Consultation Response from Chris Bembridge KC, Highways Development Management
2023/91715 Mohaddis E Azam Education Centre And Masjid E Madani, 225C, Ravenshouse Road, Dewsbury Moor, Dewsbury, WF13 3QU
Demolition of existing mosque and erection of mosque and education centre
Date Responded: 15/10/2024 Responding Officer: CNB Responding Ref: K14-5SE/4

DWG NO : AIB / 02 REV :

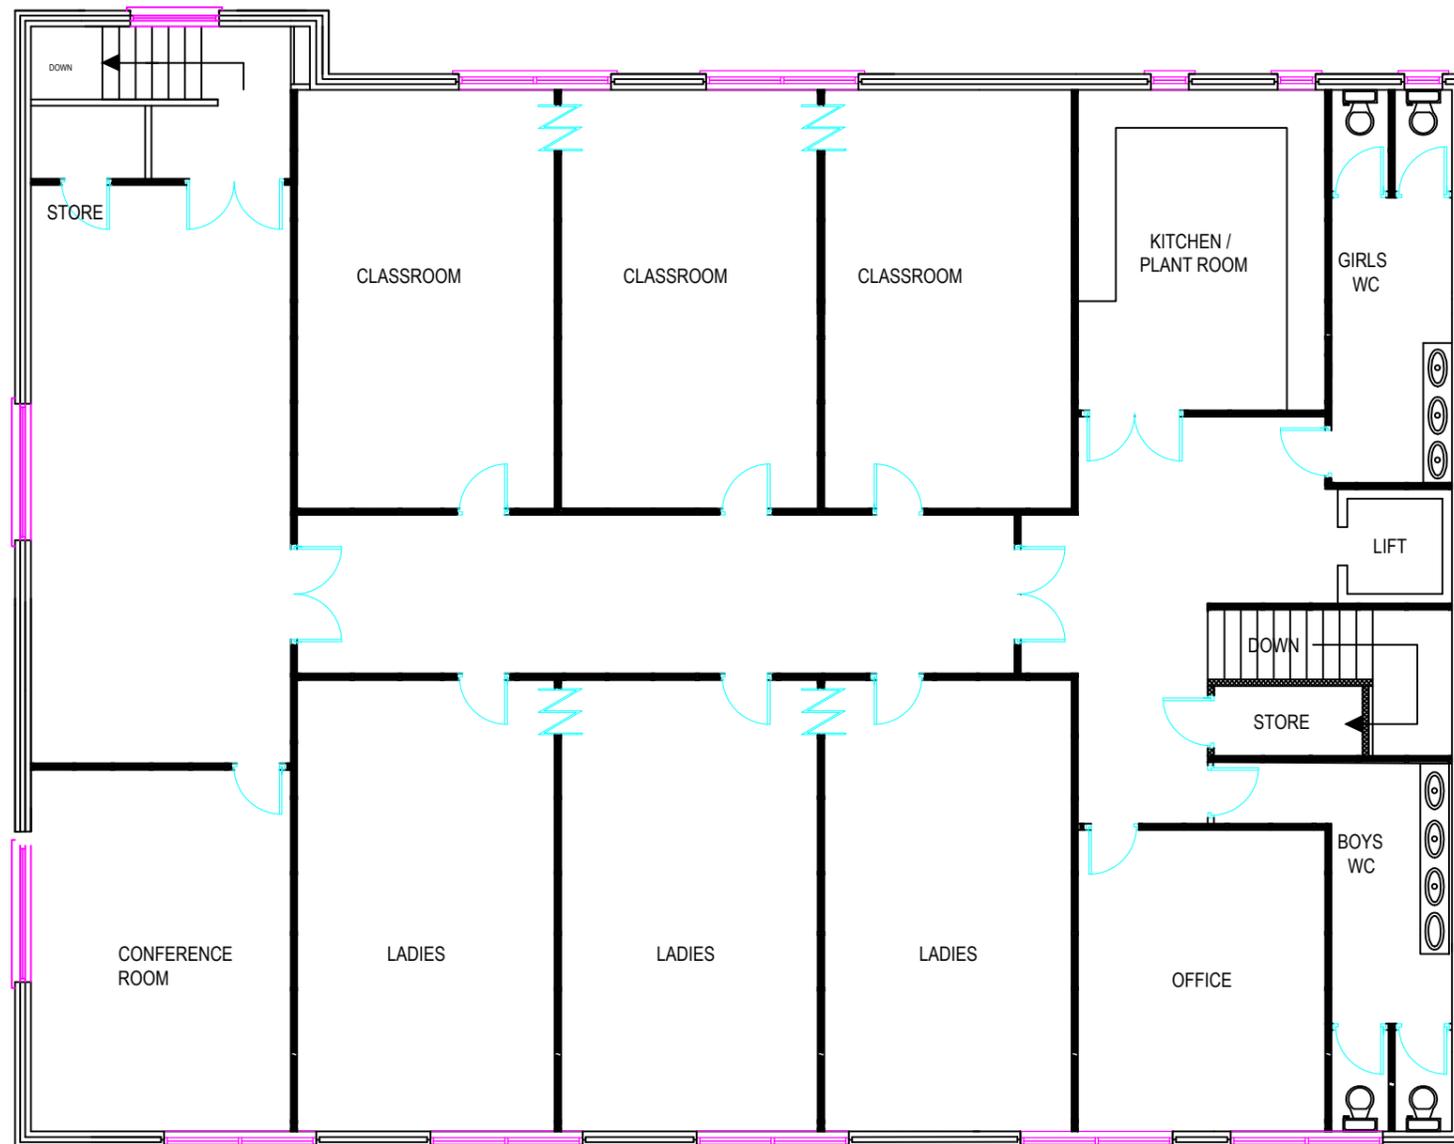
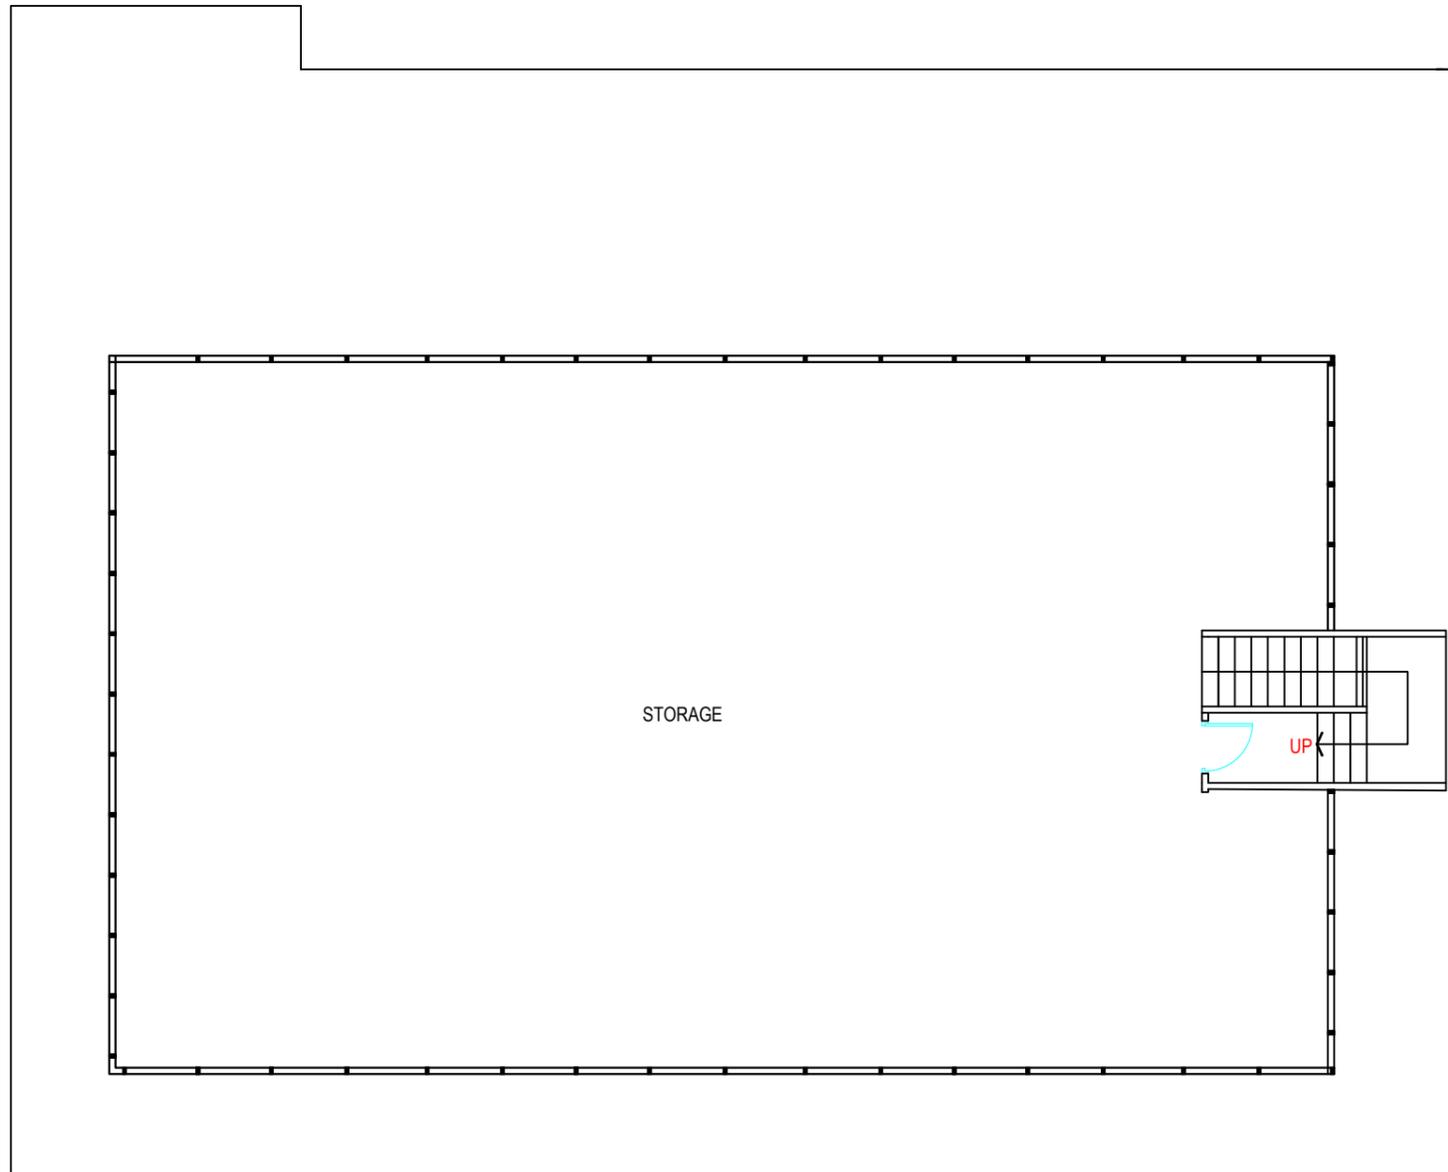
It is also noted that the within the transport statement, paragraph 2.3 Development Proposals suggests that the first floor will have 3 classrooms, 3 ladies' rooms, and office, a small kitchen, and toilets, however drawing No AIB/02 also shows a conference room and another room between the conference

room and the rear stairs. No mention is made in the Transport Statement for these two rooms or their use.

There is a possibility that these additional rooms could generate trips above those generated by the current use of the building. This is not addressed within the transport statement.

3 PROPOSED SECOND FLOOR
SCALE - 1:100

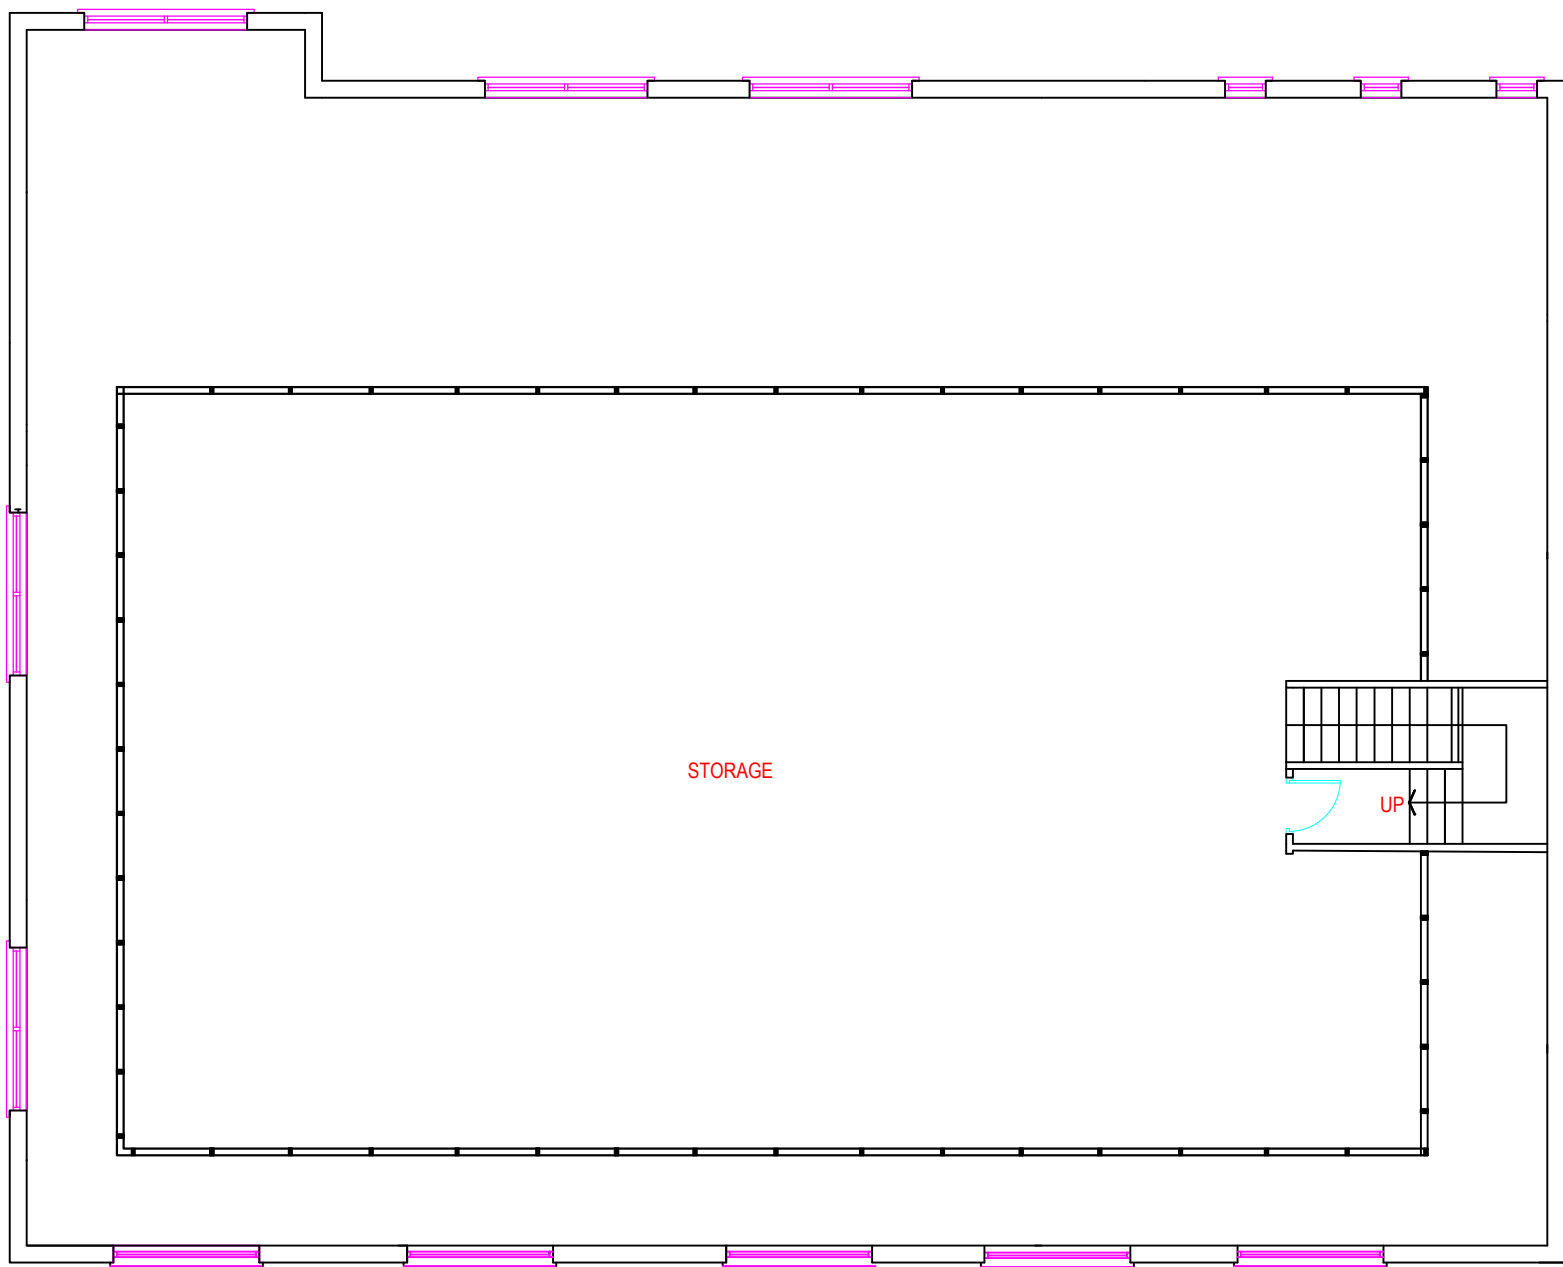
The third floor contains a room marked as “storage area”, this room is approximately 19m x 11m and this could possibly be used for other uses beyond storage.
